Ribble Valley Borough Council
Housing & Development Control

Application no: **3/2024/0266**

Address: **Pewter House Farm Commons Lane Balderstone BB2 7LN**

Proposal: **Change of use of three adjoining steel portal frame agricultural structures to five dwellings under Class Q (a) and (b) of the GPDO.**

Annex 5 – Carr Lane Visibility Plan – T4304-H-01

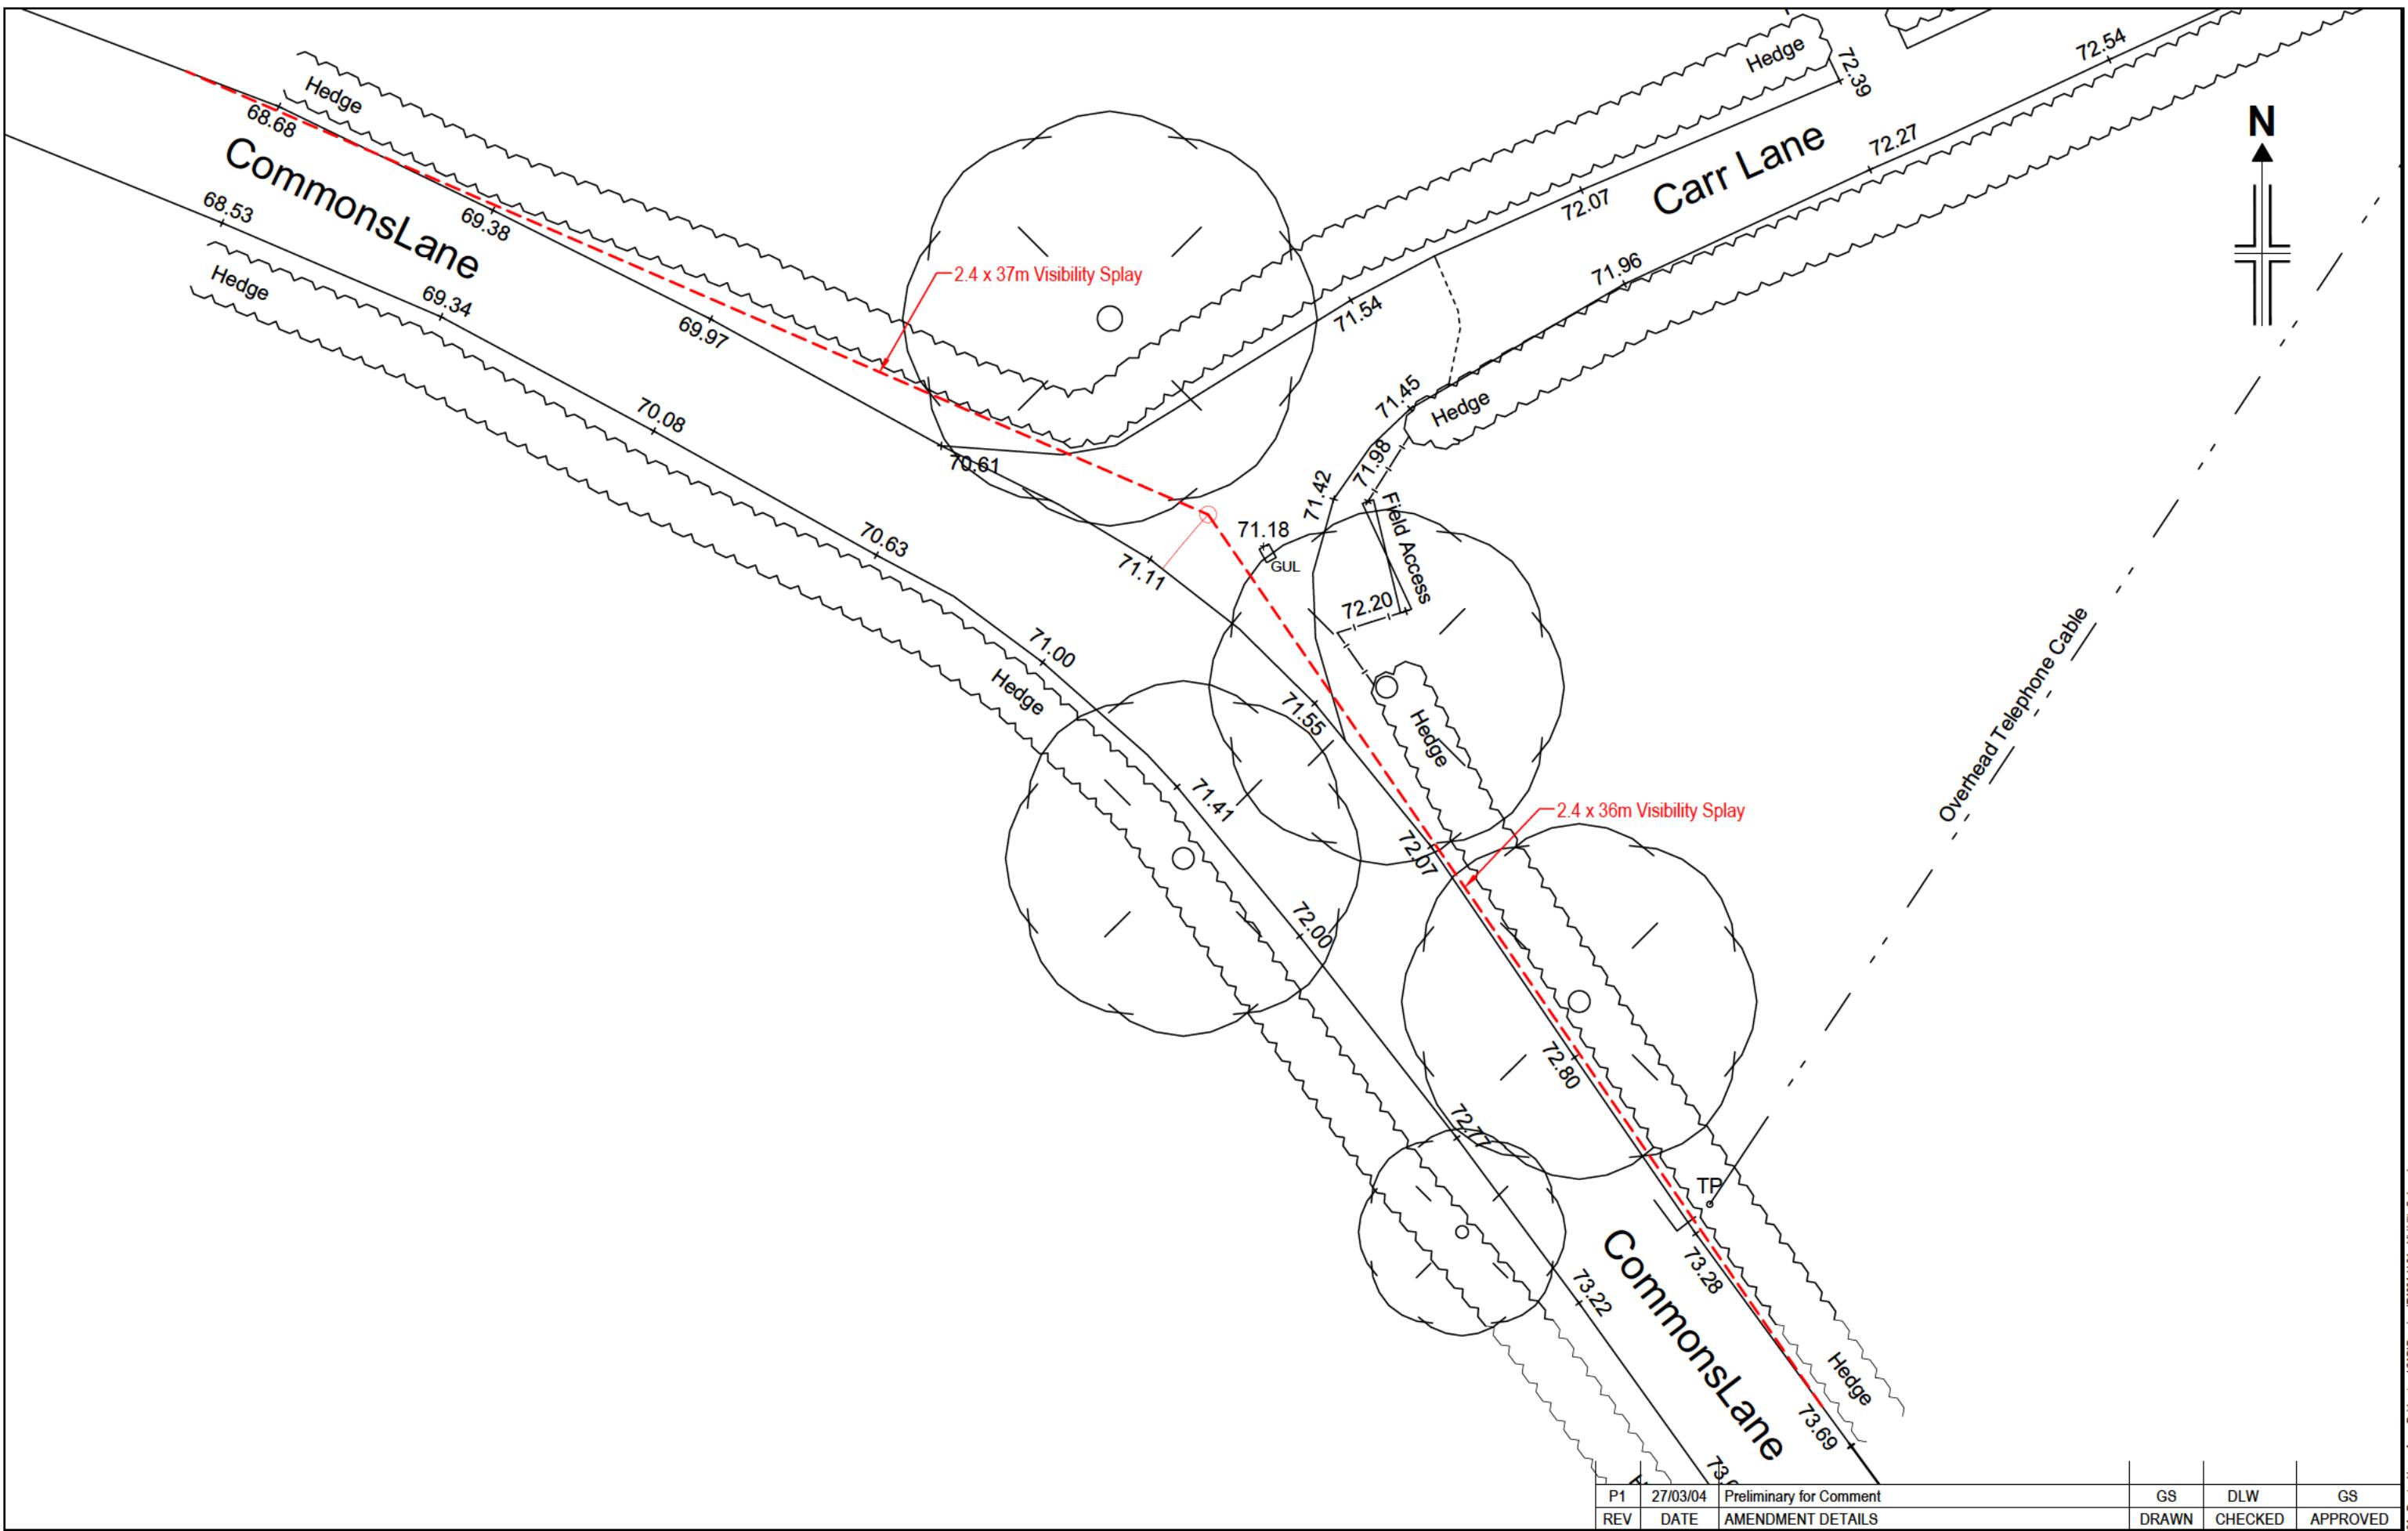
The Transport Consultant has provided PSA drawing number T4304-H.01 Rev P1 titled "Visibility Splays" which shows that the required visibility splays can be provided in both directions. However, the splays can only be provided in both directions by overlooking third party land. This is unacceptable with the Applicant being unable to protect or maintain

the visibility splays from any obstructions higher than 1m which impair visibility at the junction. Being unable to protect these splays will impact upon visibility and in turn hamper highway safety, which is a reason for an objection as stated within Paragraph 115 of the National Planning Policy Framework (2023), with the views of oncoming traffic along Commons Lane being impaired.

The LHA have further reviewed PSA drawing number T4304-H.01 Rev P1 which shows that the junction is approximately 16.3m wide as it meets Commons Lane. It immediately reduces in width to 5.2m approximately 6.7m from Commons Lane and then eventually 3.8m at a distance of 10m from the adopted highway. The LHA would expect given that the junction and Carr Lane provides access to numerous dwellings, outbuildings and farms, the junction to be a minimum of 6m wide for a distance of 10m behind the highway boundary.
